Re: Application to discharge planning condition 17 of planning permission 07245/19

Planning Portal Ref: PP-12975108

This application to discharge Condition 17 is being resubmitted in response to Decision Notice 16884/23 which refused the discharge of the condition.

Drawing title
**SITE SECTIONS
DRG 4**

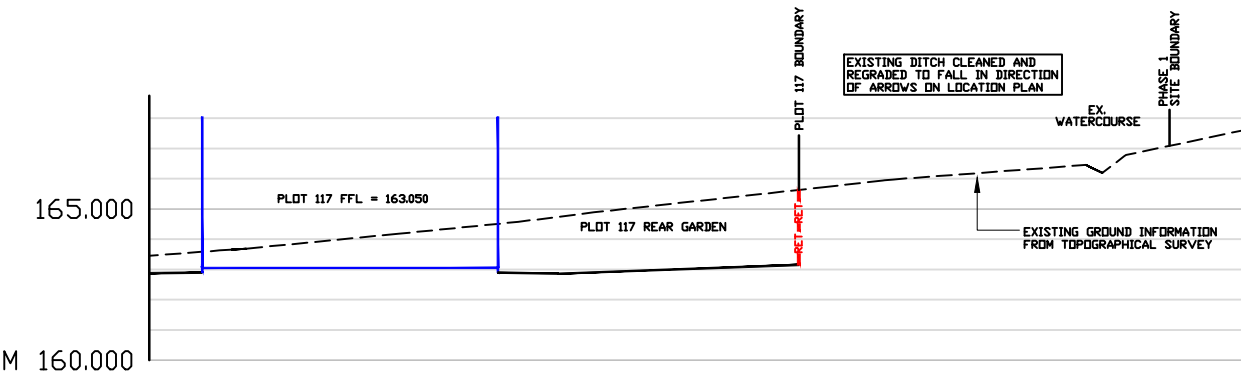
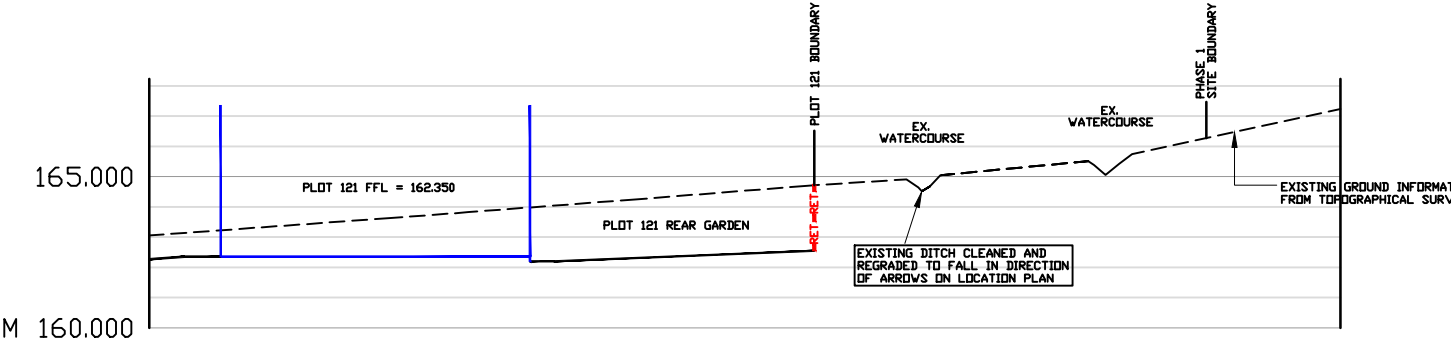
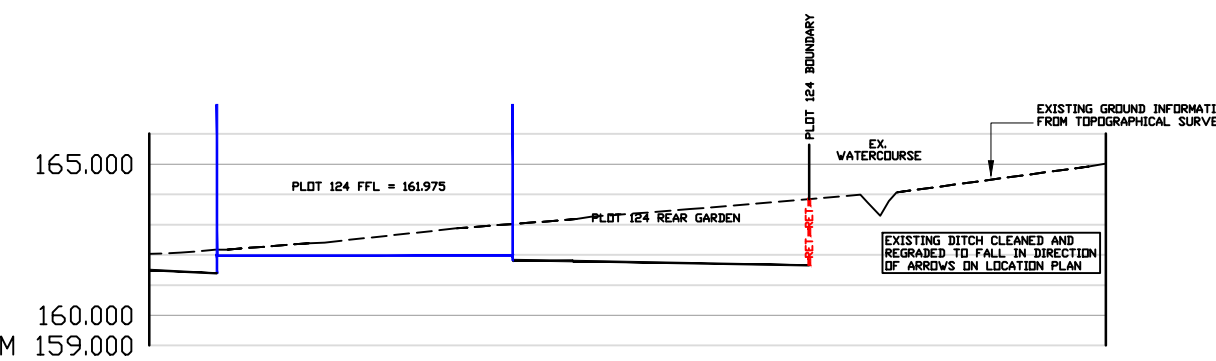
iii. Swale slopes are excessive at 45 degrees, these need to be reduced.

The swale construction is informed by the parameters plan approved pursuant to the outline planning consent 07245/19. The protection of trees is being prioritised, resulting in a steeper slope design. Gentler slopes would necessitate the removal of more trees. To keep the areas around the swales as green as possible, we are installing erosion control matter over and above the minimum requirements. This will offer additional protection to the 45 degree batters.
